Application reference number	2025/0930
-------------------------------------	-----------

Application Type	Variation of Condition
-------------------------	------------------------

Proposal Description:	Variation of condition 2, in relation to application 2020/1387 "Residential development of 7no. dwellings and associated works" to allow for amendments to house type D.
Location:	14 Roughbircworth Lane, Oxspring, Sheffield

Side Elevation 1
Scale:1 : 50

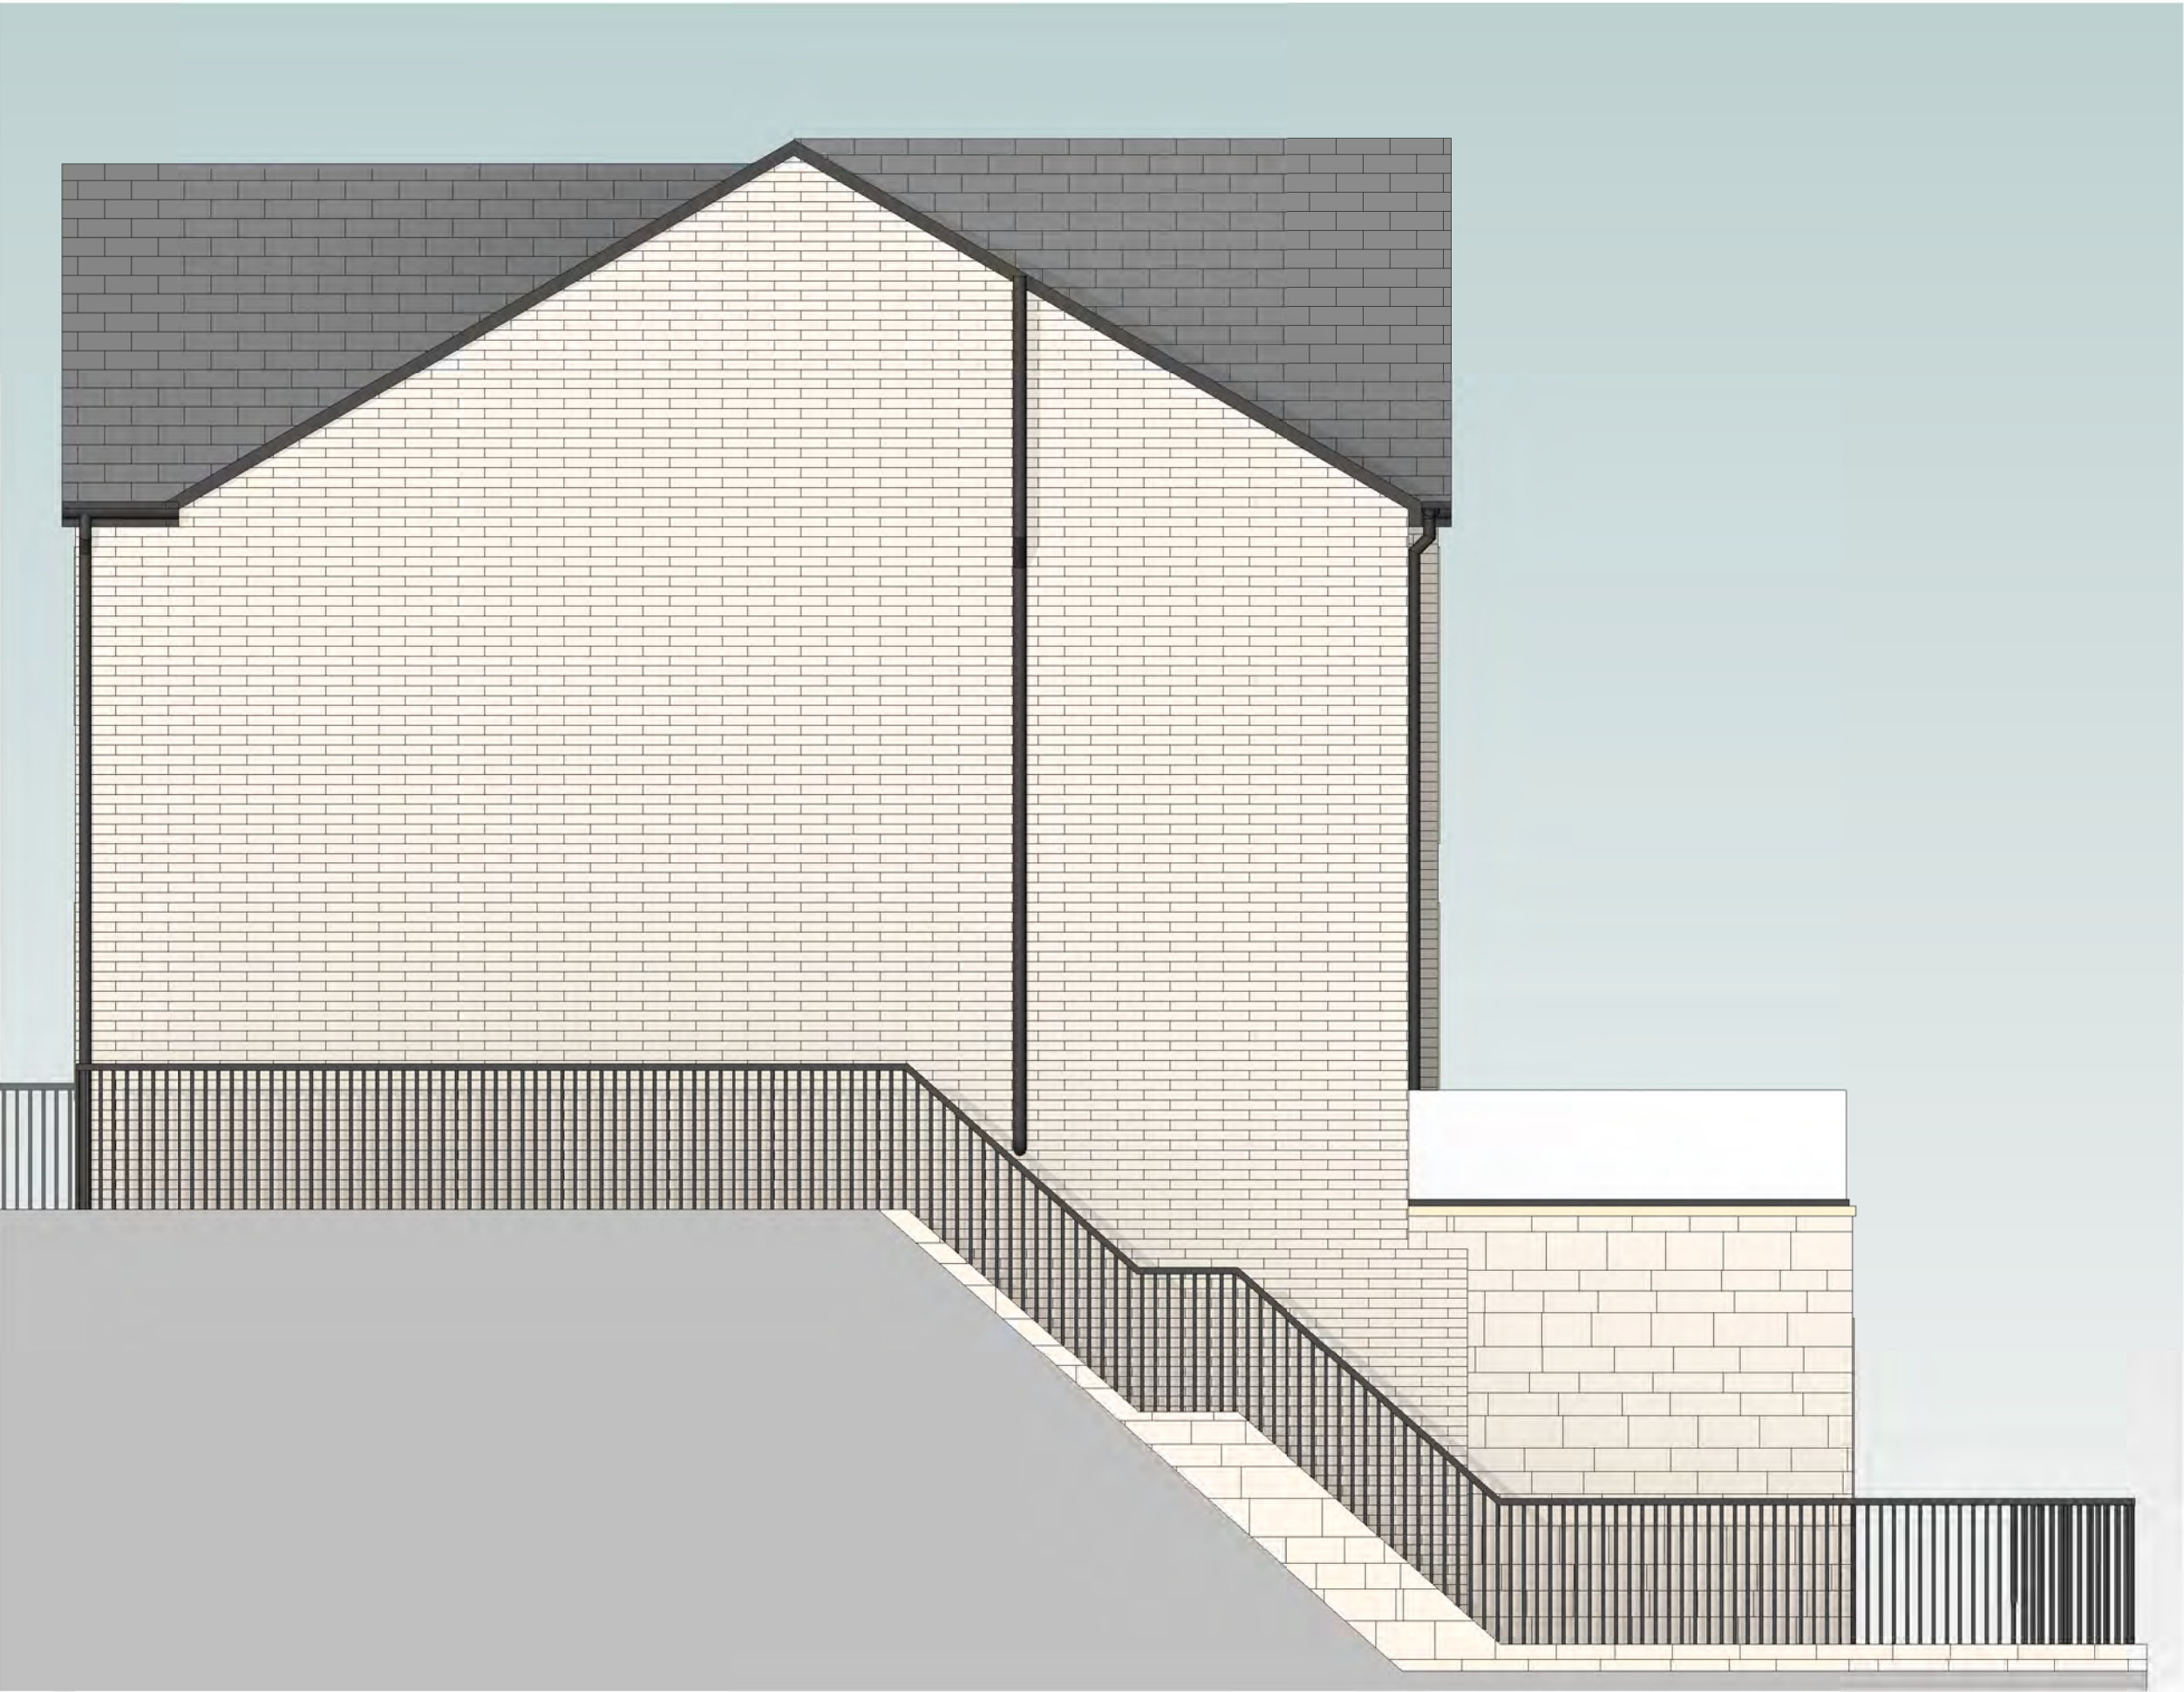
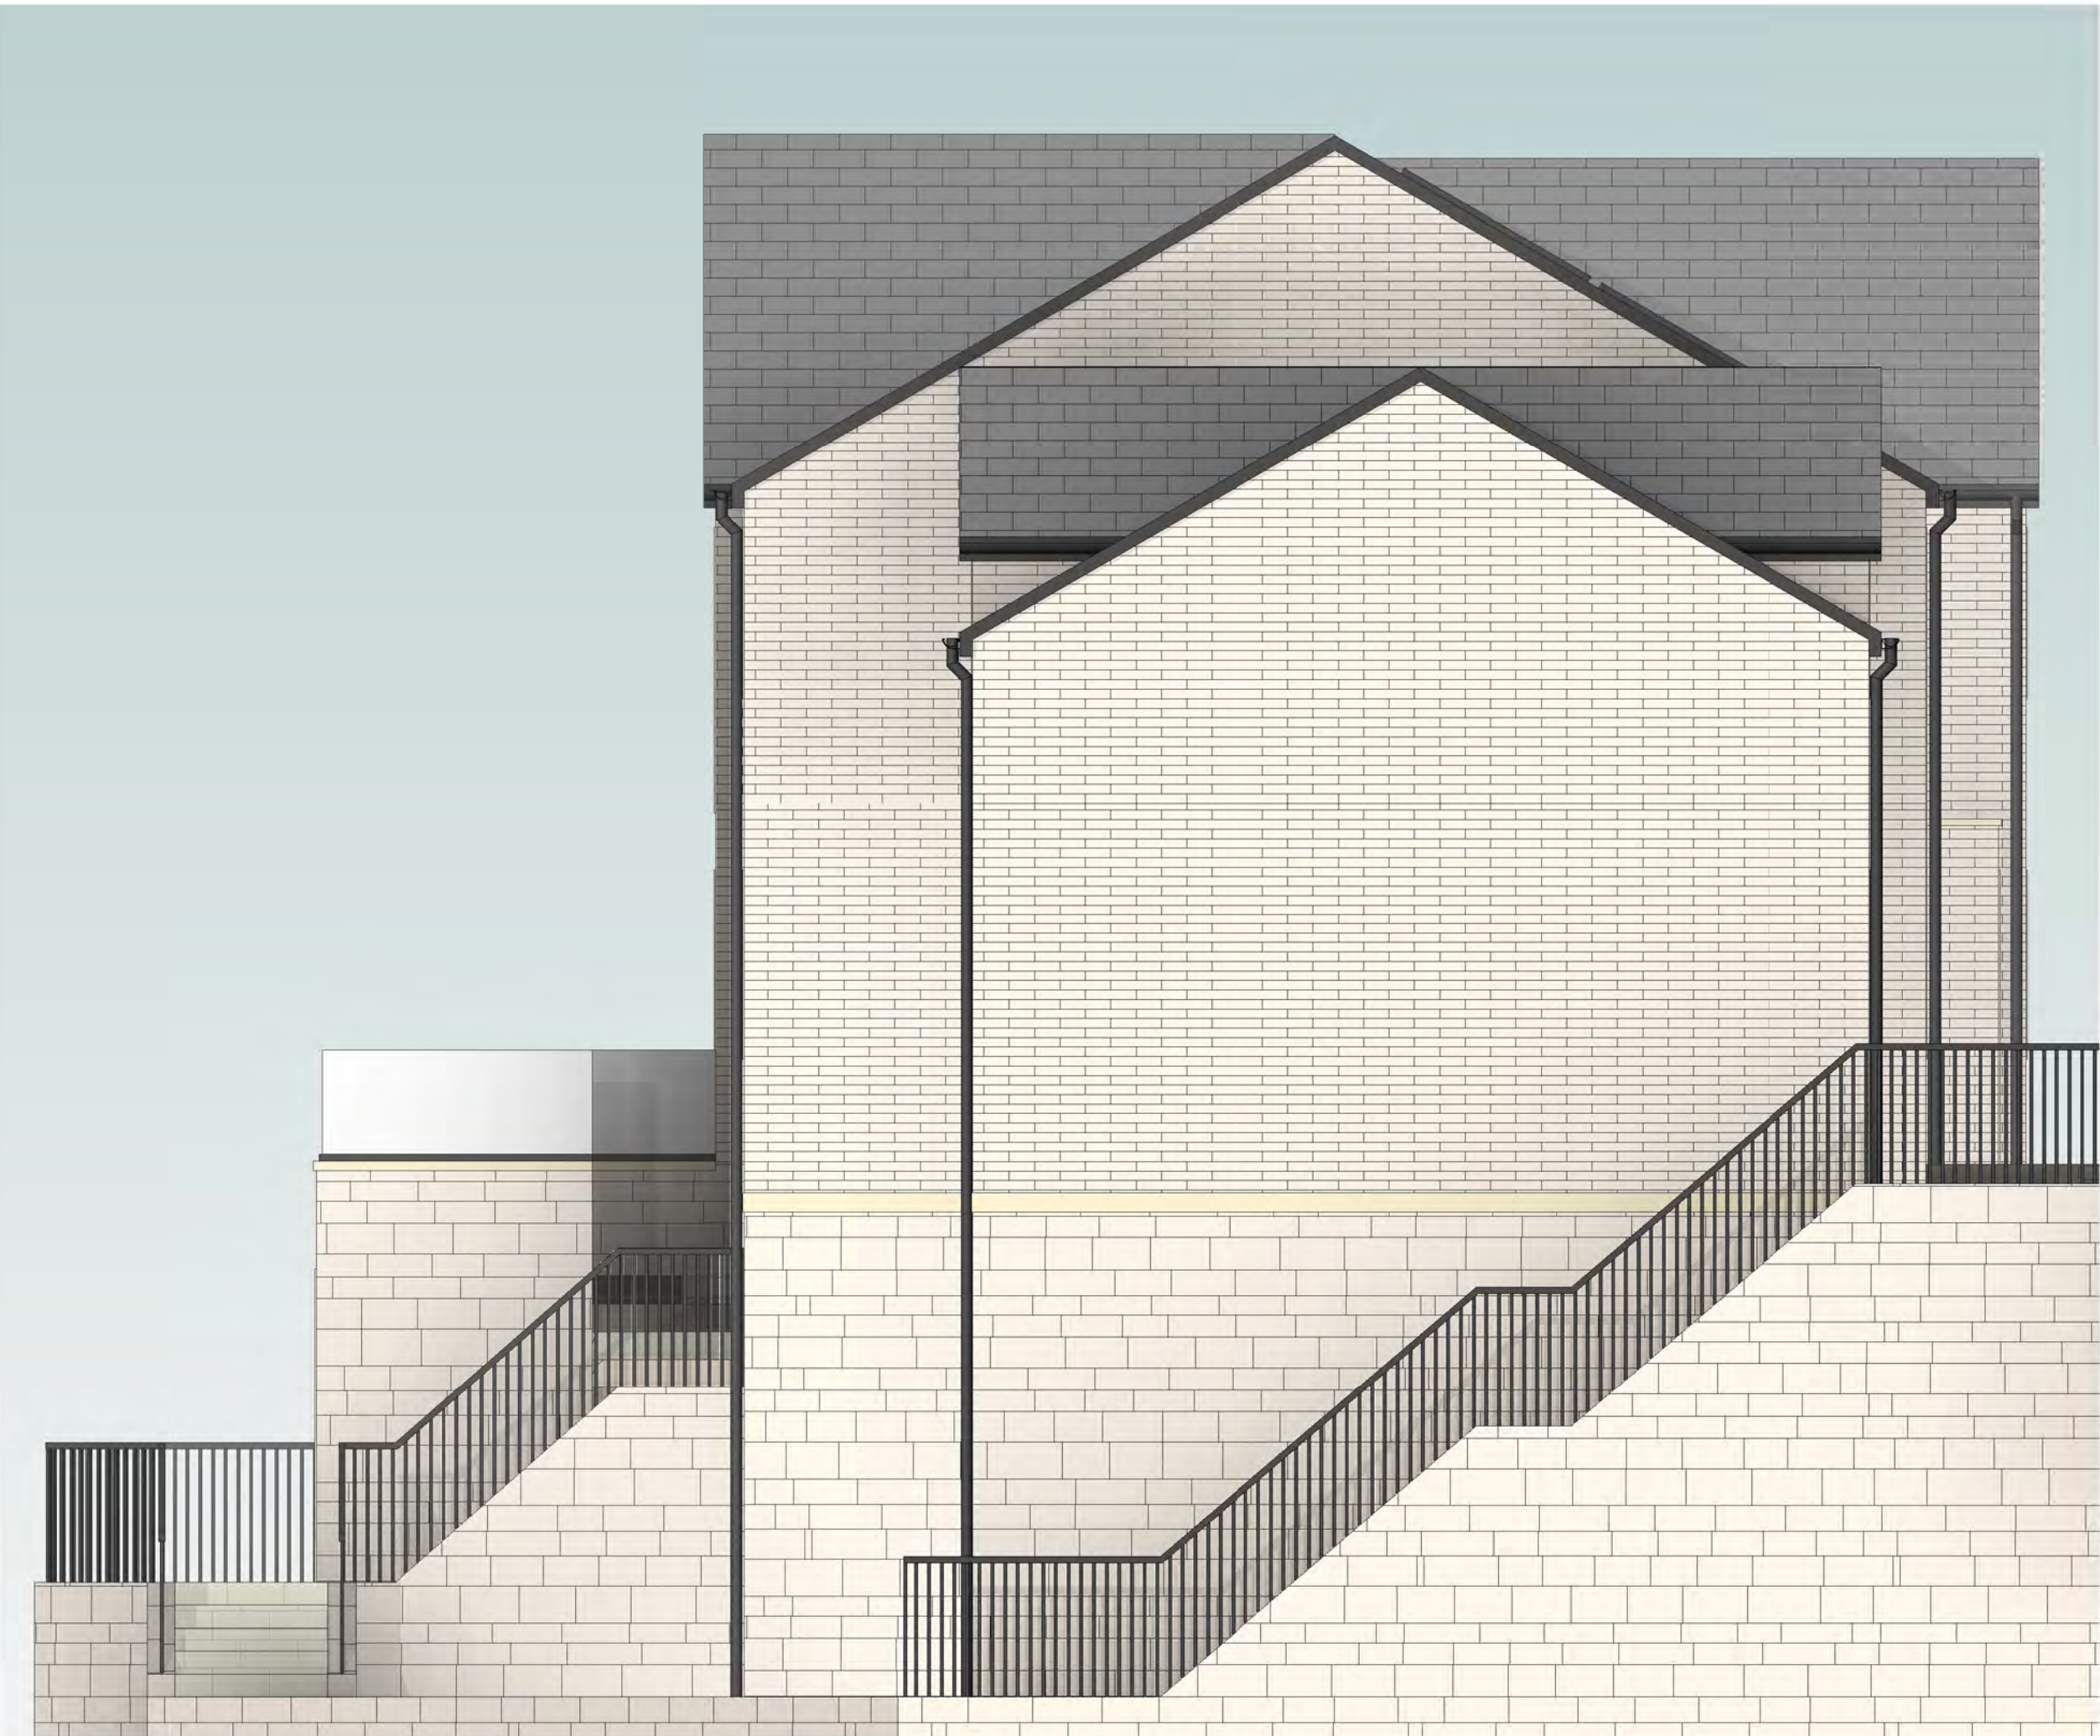
The first scheme submitted within the application was considered to be unacceptable as it heavily featured a vertical emphasis to the frontage and windows, which was not in keeping

with the original design and the design of the adjacent dwellings. With these individual elements emphasizing the height of the building and thereby not reducing its massing and scale, therefore amendments were requested. The applicant has now amended the scheme and has provided the following visuals in support of the revised scheme application.

The following justification has been provided: - 'The most notable change is the reduction in vertical emphasis across the elevations. The composition has been rebalanced to read more horizontally, with a clearer hierarchy of elements and a more traditional arrangement of built form. At the rear, we have also introduced a change in stone between the lower ground floor and the upper levels, which helps to visually break down the mass, reduce perceived height, and better anchor the building into the site.

We have also simplified the overall form by removing the larger flat roofed elements from both the front and rear elevations. This has allowed the building to appear more clearly as a series of traditional pitched roof forms, including the rearrangement of the rear gable, which helps reinforce a consistent architectural language across all elevations.

Fenestration has been carefully considered. The overall amount of glazing has been reduced and rationalised, and the previous vertical emphasis has been softened. Where vertical elements remain, these have been refined to reflect more traditional proportions. For example, the stair glazing has been amended from a single larger opening to two slimmer vertical slots, which is more in keeping with typical over-stair arrangements seen within the local area.

At the rear, larger openings have also been reconsidered and now take the form of more traditional arrangements, with large openings broken down and expressed with Juliet-style detailing rather than as expansive areas of uninterrupted glazing. This helps to better align the rear elevation with the overall architectural language of the dwelling, whilst still responding to the outlook and relationship with the other dwellings on the site which make use of Juliet style glazing.

The dormer elements above the garage have also been reduced in scale to better reflect more typical proportions within the area and reduce their visual prominence within the roofscape.
